Subject: Rolling Hills Ranch Filing No. 2 Final Plat, Review #2 (SF-20-020)

The Park Operations Division of the Community Services Department has reviewed the Rolling Hills Ranch Filing No. 2 Final Plat development application, Review #2, and has the following additional comments of behalf of El Paso County Parks:

ROLLING HILLS RANCH FILING 2
AT MERIDIAN RANCH
STREET AND UTILITY PLANS
SIDEWALK PLAN

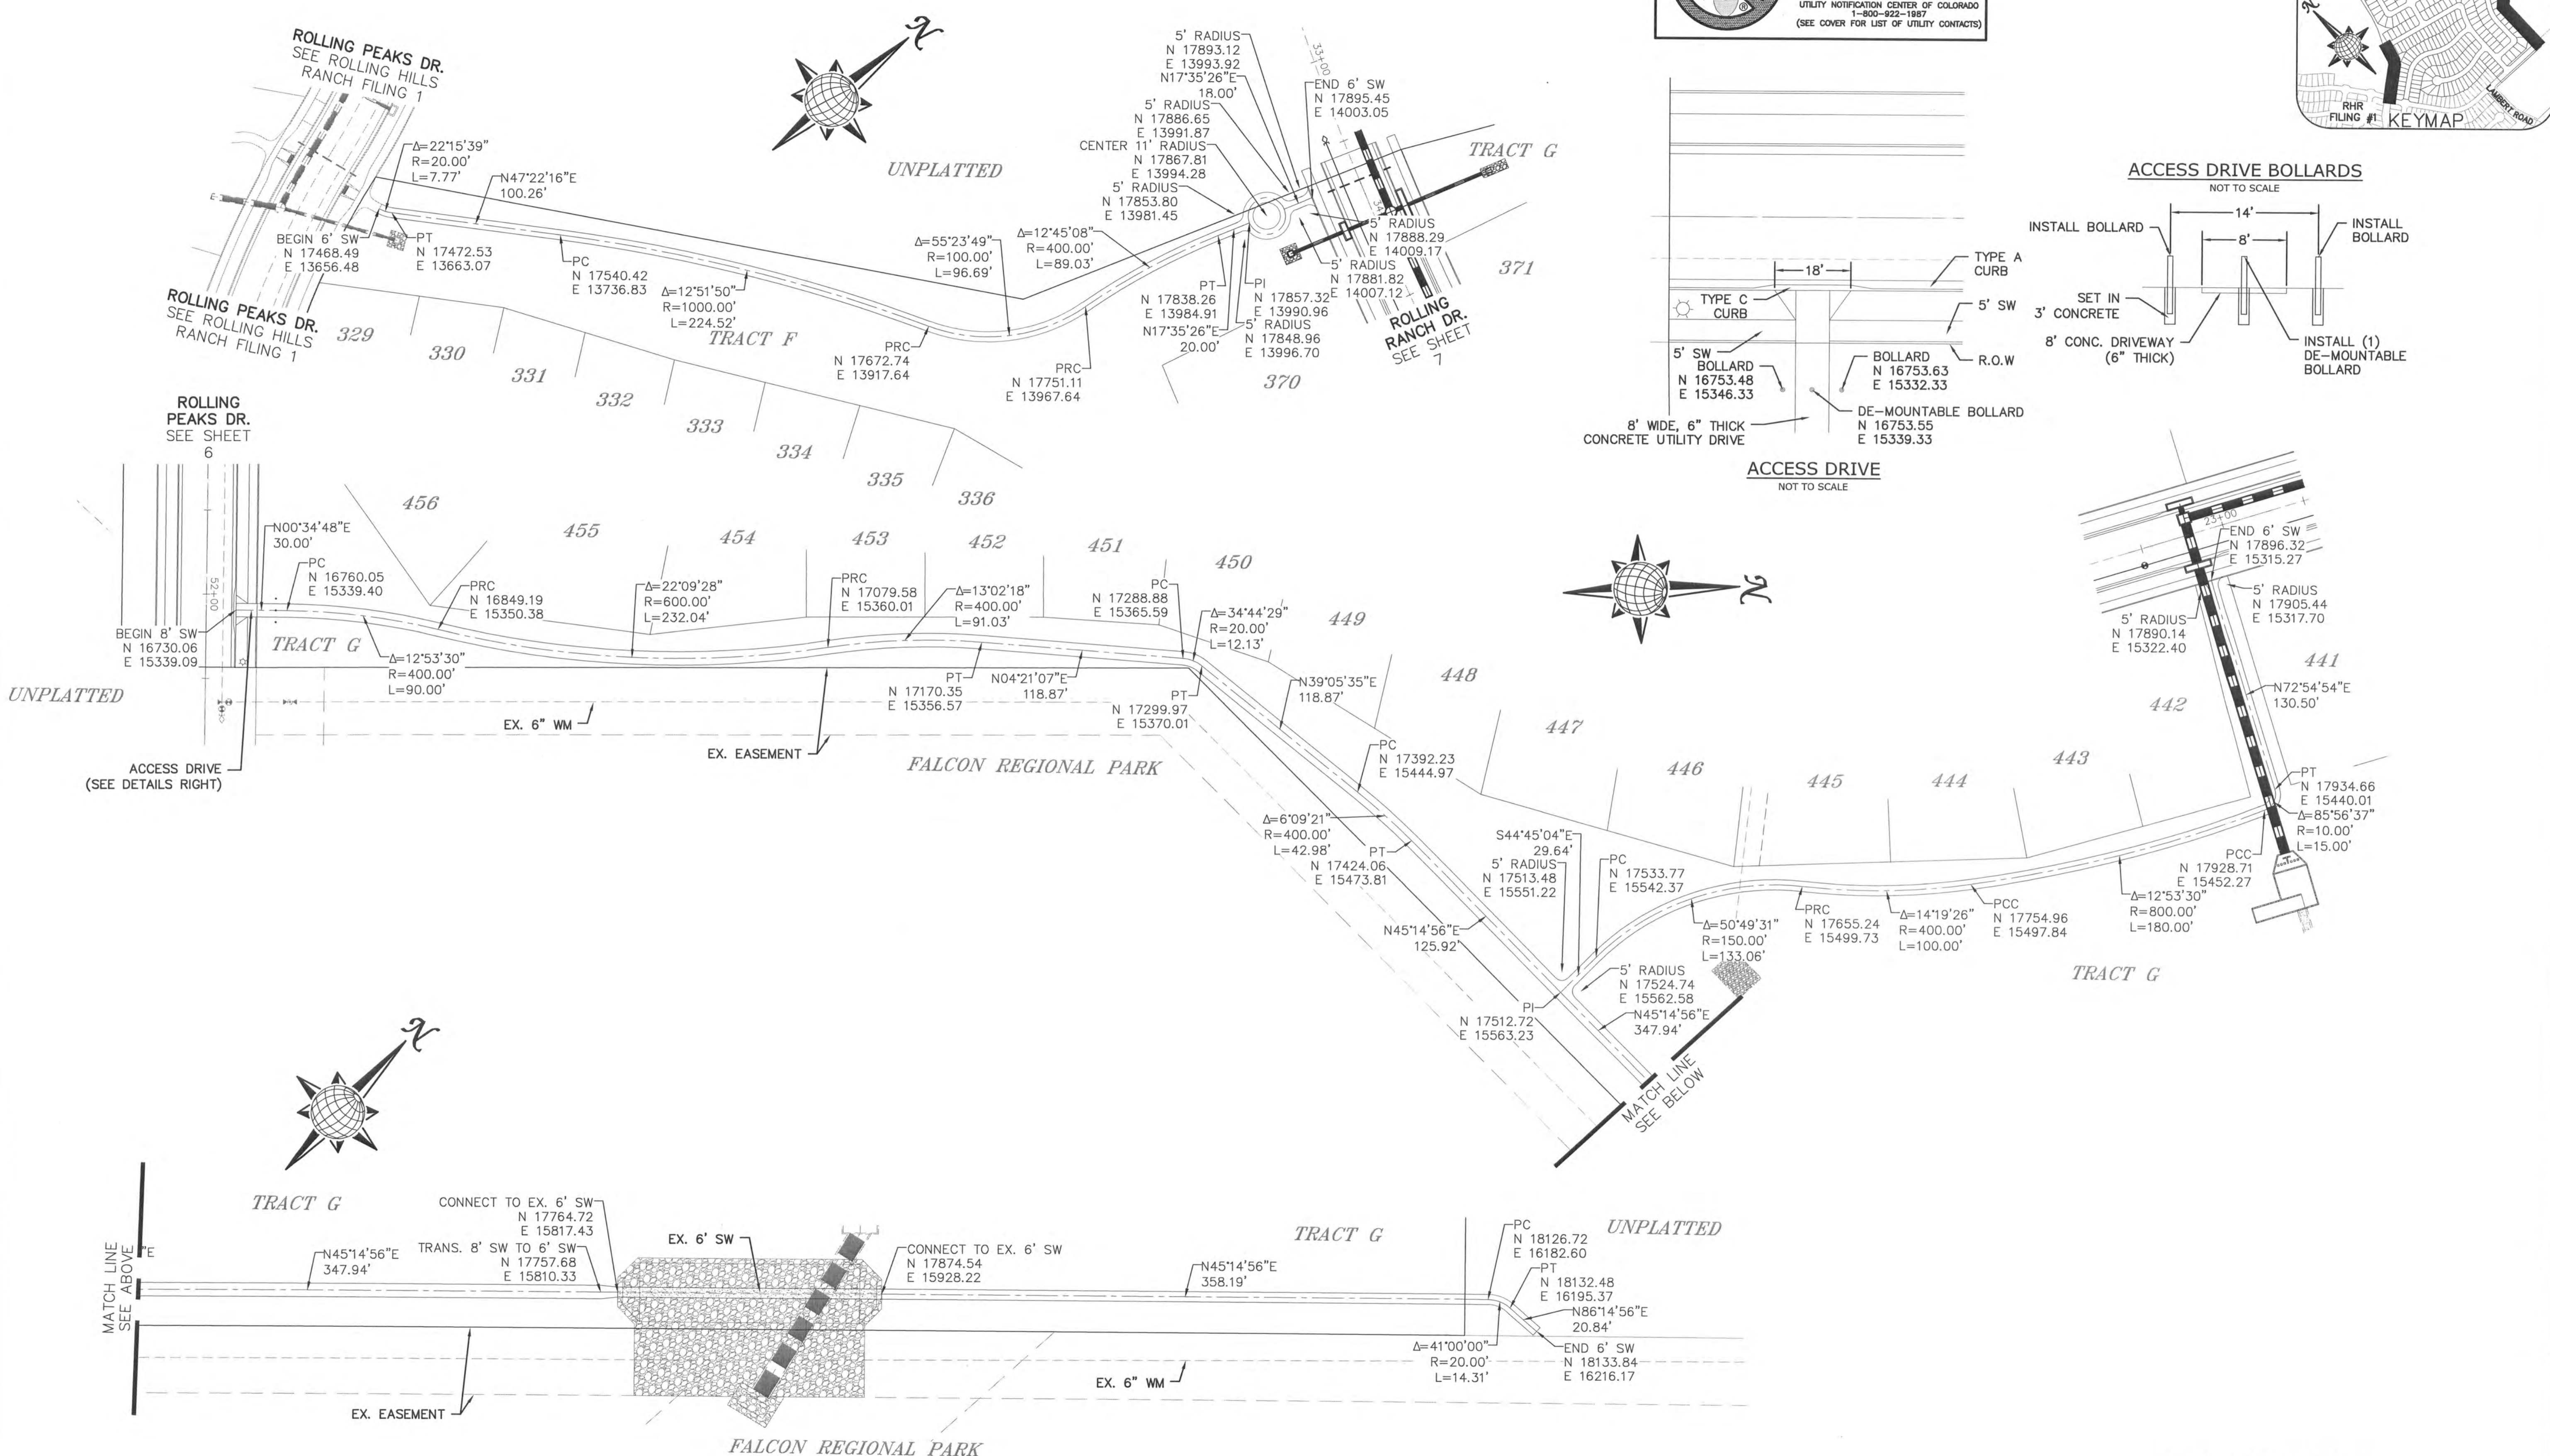
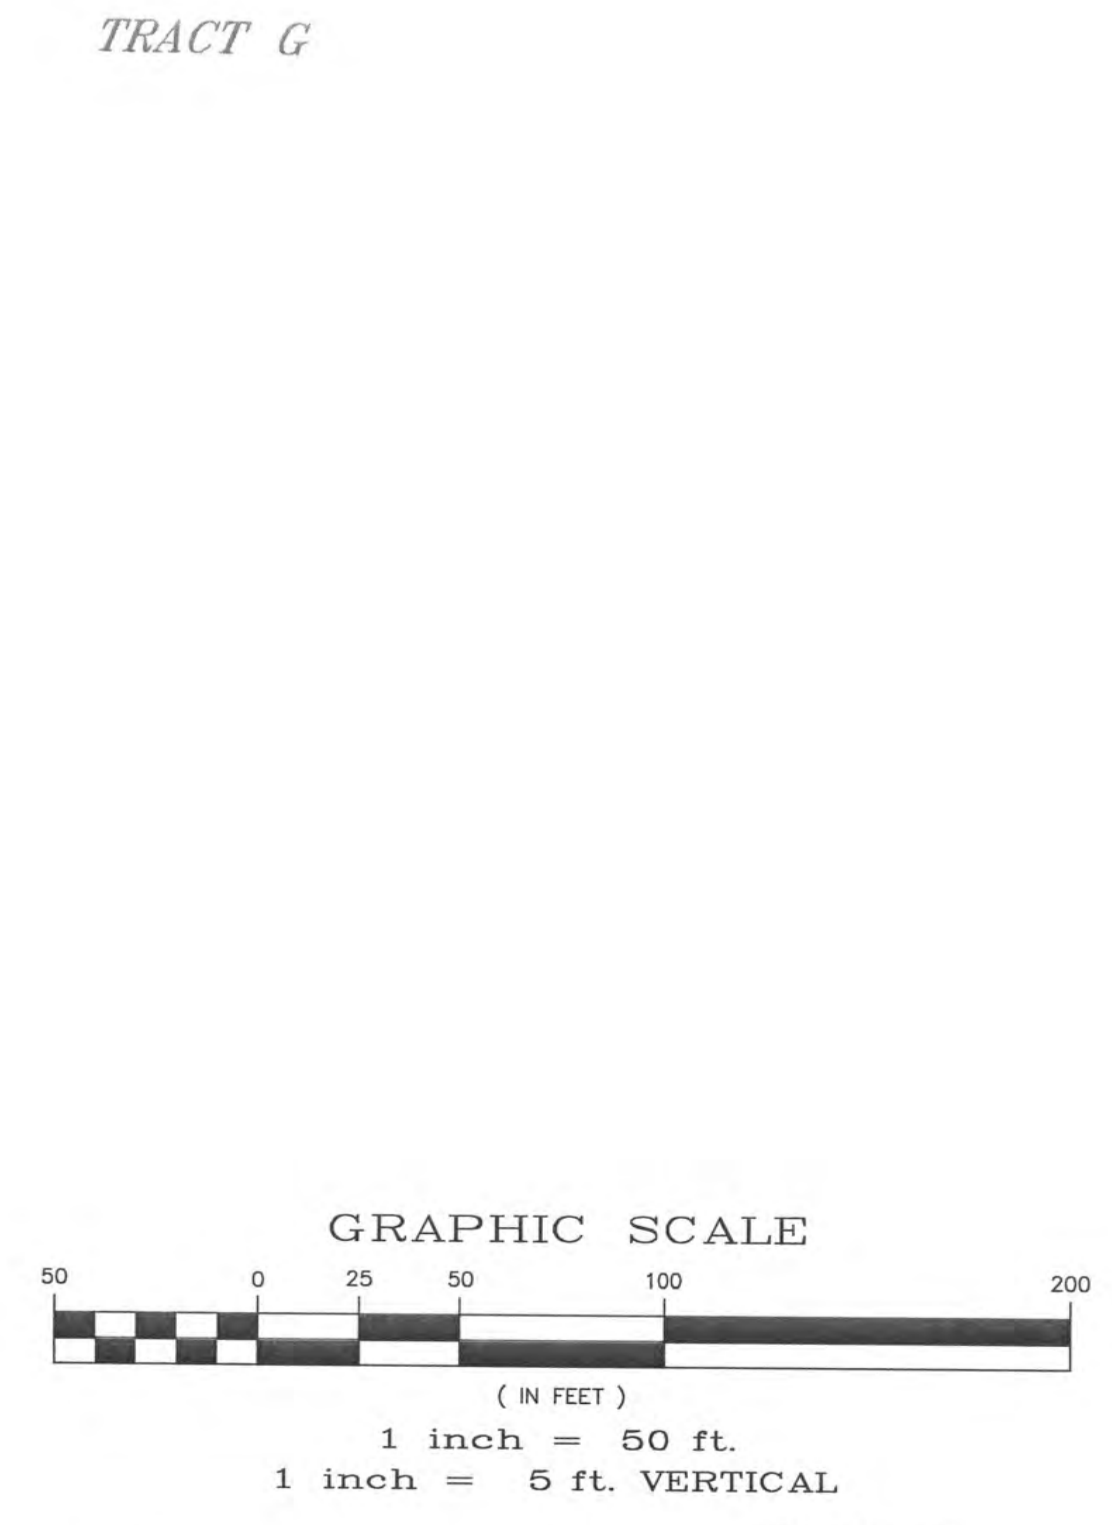
Page eighteen (18) of The Rolling Hills Ranch Filing No. 2 Final Plat construction drawings depict the construction of a 6' concrete sidewalk adjacent and entering Falcon Regional Park, owned by El Paso County Parks. The sidewalk briefly enters and exits the Park property behind proposed Lots 450 and 451, then enters the Park property further to the northeast, where it terminates, but is proposed to connect to internal park trails. While staff appreciates the applicant's continued willingness to provide extensive recreational opportunities and multiple trail connections to both internal and external recreational facilities, such as Falcon Regional Park, staff strongly recommends the following:

- The developer must work closely with El Paso County Parks staff to coordinate the point at which the developer's concrete sidewalk terminates in Falcon Regional Park. Plans are being developed currently for baseball field facilities near the vicinity of the trail terminus, so coordination is of an utmost importance.
- The developer and/or Meridian Service Metropolitan District must request a permanent non-exclusive easement/license agreement with El Paso County for the location and construction of the 6' concrete sidewalk within Falcon Regional Park. Coordination with Parks staff will allow for accurate locations of the easements.
- The easement(s) must be endorsed by the Park Advisory Board and approved by the El Paso County Board of County Commissioners prior to the recording and subsequent construction of Rolling Hills Ranch Filing No. 2 Final Plat.
